From: Carol Reynolds
Sent: 16 February 2018 13:51
To: Planning.Responses
Subject: FW: LU/426/17/DOC - Approval of acoustic barrier for Fitzalan Relief Road - WSCC highways response dated 25th January 2018

**Drawing Title / Scenario:
Acoustic Fence Detail**

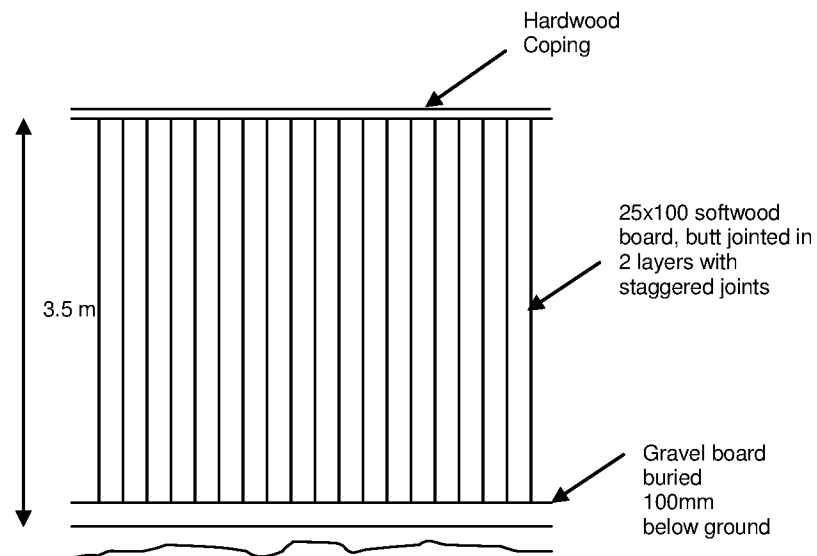
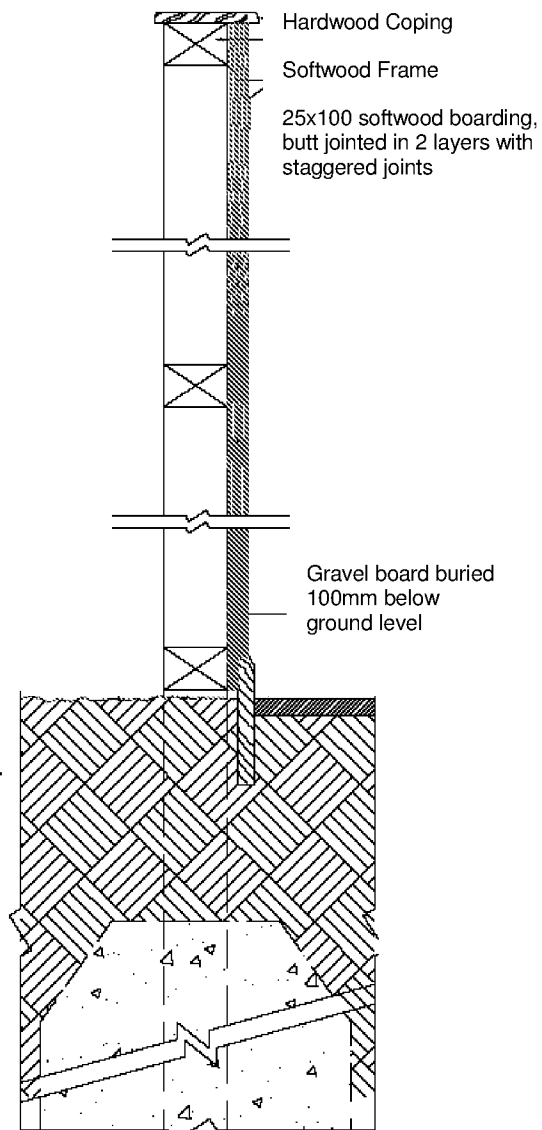
Environmental Health: No objection in so far as the integrity of the acoustic barrier is maintained. This particularly relates to ensuring no gaps to the base, hinge points and closing points of such gates and to the ongoing proper maintenance of such.
